Gravesham Borough Council

Lower Thames Crossing

Deadline 9a submission

Gravesham BC response to doc 9.187 Post-event submissions, including written submissions of oral comments, for ISH11 – by the Applicant (REP8-110)

*Local Landscape Character Area boundaries of the Kent Downs AONB LCA, West Kent Downs, Sub-areas Cobham and Shorne*

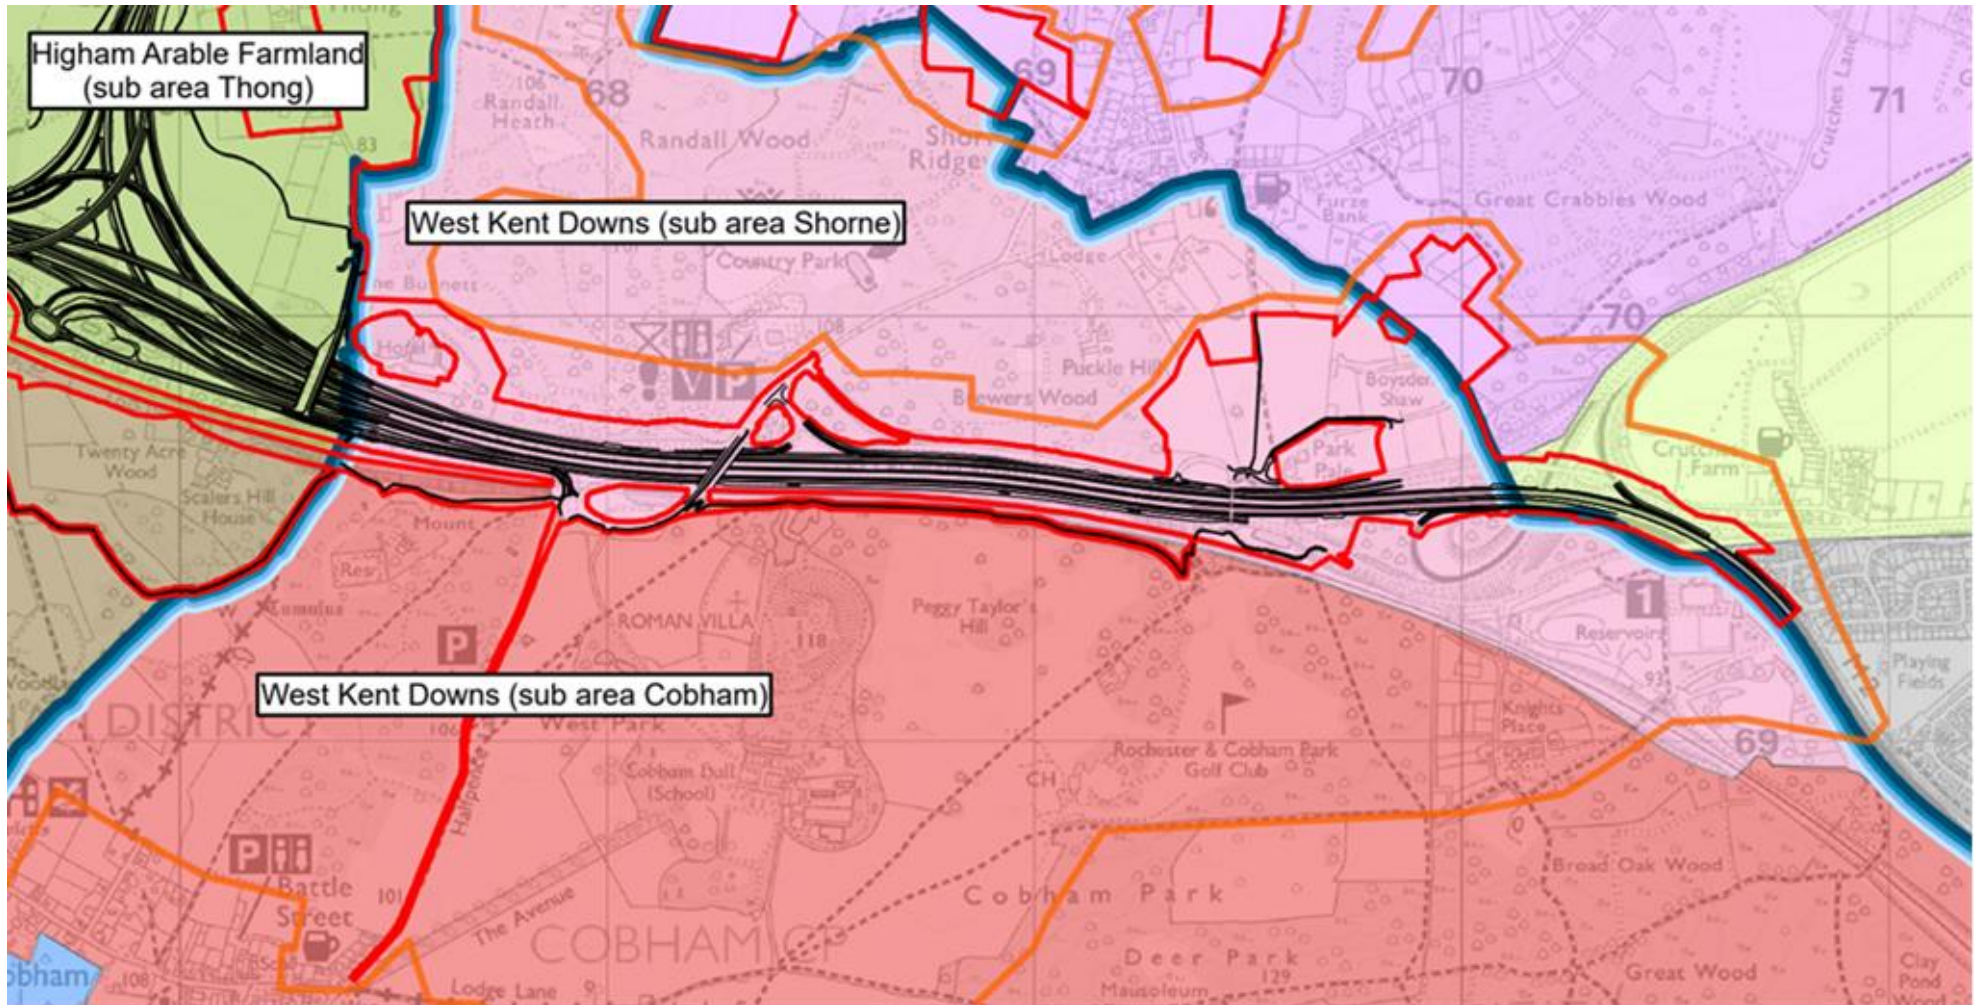
Re A.3 Hearing Action Point: Local Character Area boundaries.

It is our view that the Applicant's response does not support the changes they made to the boundary between the Shorne sub-area and Cobham sub-area LLCAs in their 2020 and 2022 assessments.

The Applicant changed the boundary between the LLCAs for their 2020 LVIA, and it is clear that the change in boundary position influenced the landscape Sensitivity and Magnitude of effect of the proposals on these areas, and thus altered the findings of the landscape assessment of these two LLCAs.

In their post-event submission for ISH11 (REP8-110) the Applicant now states the reasons for the change in the 2020 LVIA are not known. This being the case, then by inference the Applicant cannot support their own position, and the original boundary should be reinstated, and the assessment reviewed.

The Applicant's response then goes on to explain a further change in the boundary made between the assessment of 2020 and 2022. The Applicant's explanation includes the prominence of the HS1 corridor and A2 corridor from the southern fringes of Shorne Woods Country Park as one of the reasons for moving the LLCA boundary. Document 6.2 Environmental Statement – Representative Viewpoints – Winter and Summer Views (1 of 8) at Figure 7.17 Viewpoint S-13 Sheet 3 of 3 clearly shows the significant effect of the wooded central reservation on this area, and its role in forming a strong boundary. It is therefore our view that the LLCA boundary should be reinstated.
